CITY OF ALBUQUERQUE

September 8, 2014

**RE: Winrock Redevelopment Dave and Busters
Grading and Drainage Plan
Engineers Stamp Date 8/14/14 (J19D038)**

GRADING & DRAINAGE
PLAN

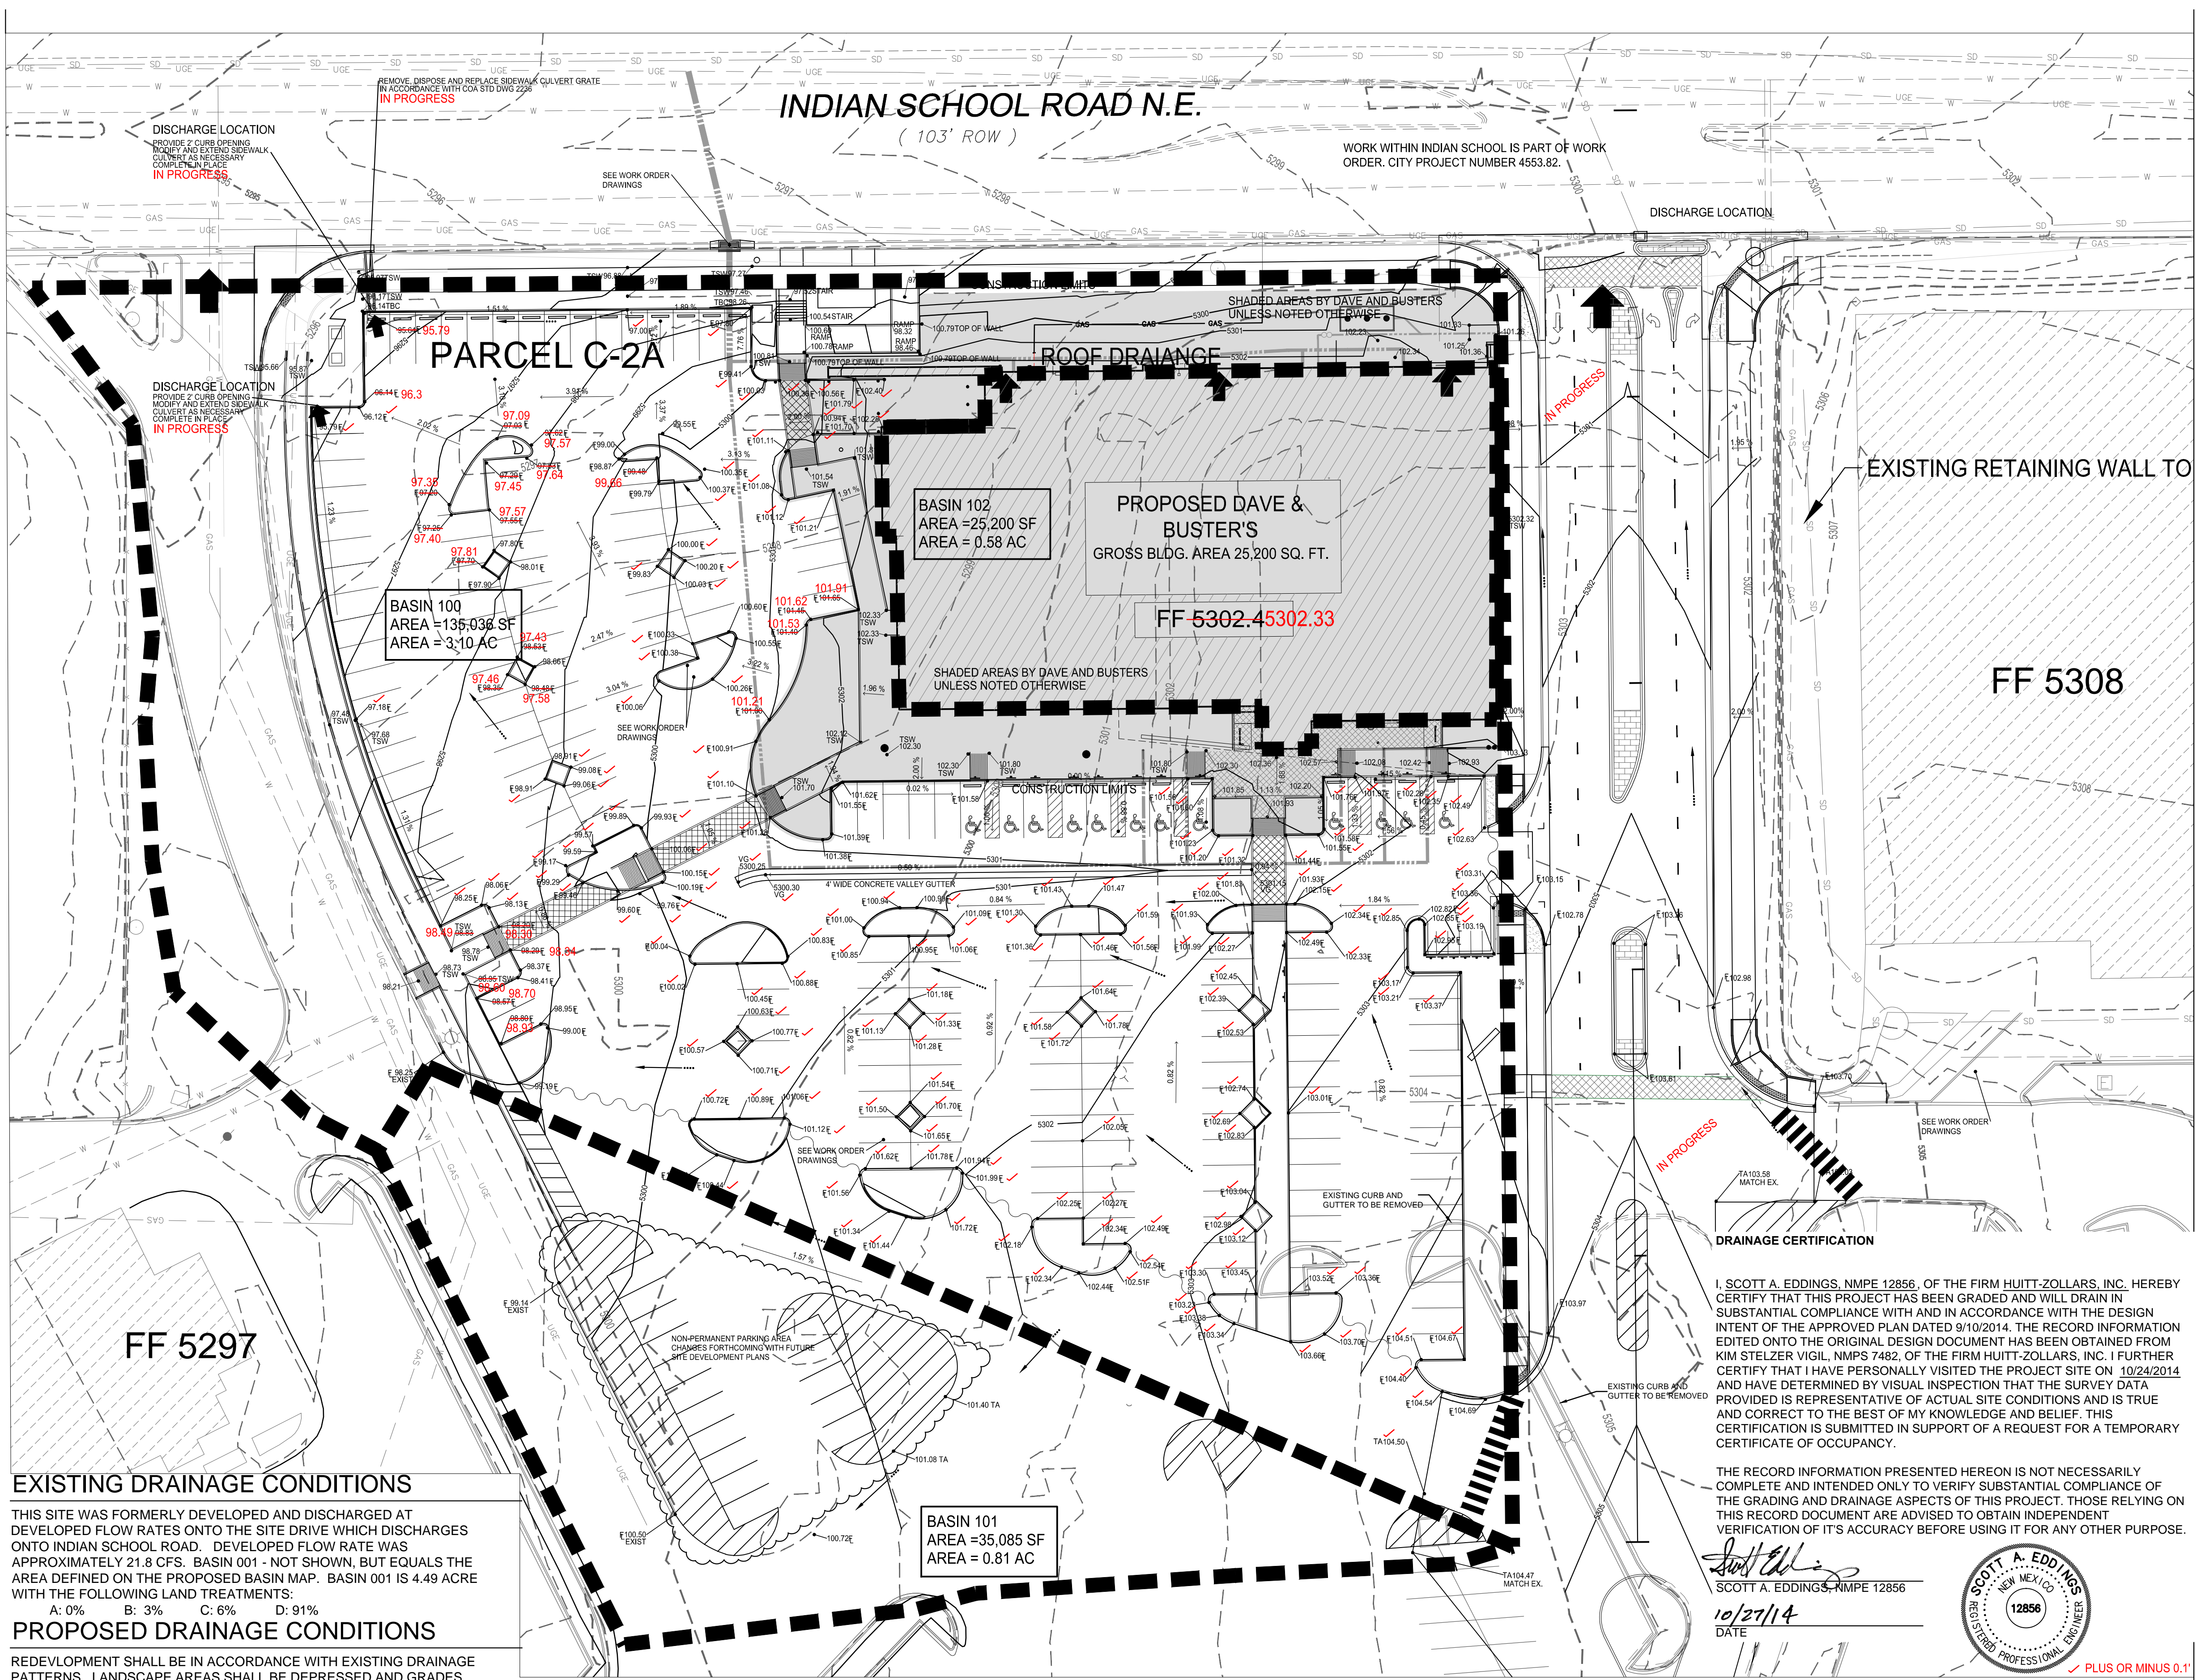
1. Regarding the parking islands on the southwest corner: It is not clear whether new parking islands are being built or if striping only. Contour lines extend ✓ though these islands, but a return curb would typically be required.

2. Detail all proposed islands along on south side of roadway/driveway showing spot Flowline Elevations.
3. Show a valley gutter and flowline elevations at the new curb returns at the new access. Label streets.

4. The Flowline Elevations on the parking islands are offset. It appears that the drafting layers are not correctly aligned.
5. I understand that the parking and traffic circulation were amended through an administrative amendment, but there seems to be a discontinuous pedestrian path though the parking island along at the south side of the new access.

6. If the Site Plan is being amended, do the drainage basins delineated on Site Plan SDP-6 (stamp date 10-3-13) still apply to this new condition?
7. A new ESC Plan will be needed with this amendment to the G&D plan.
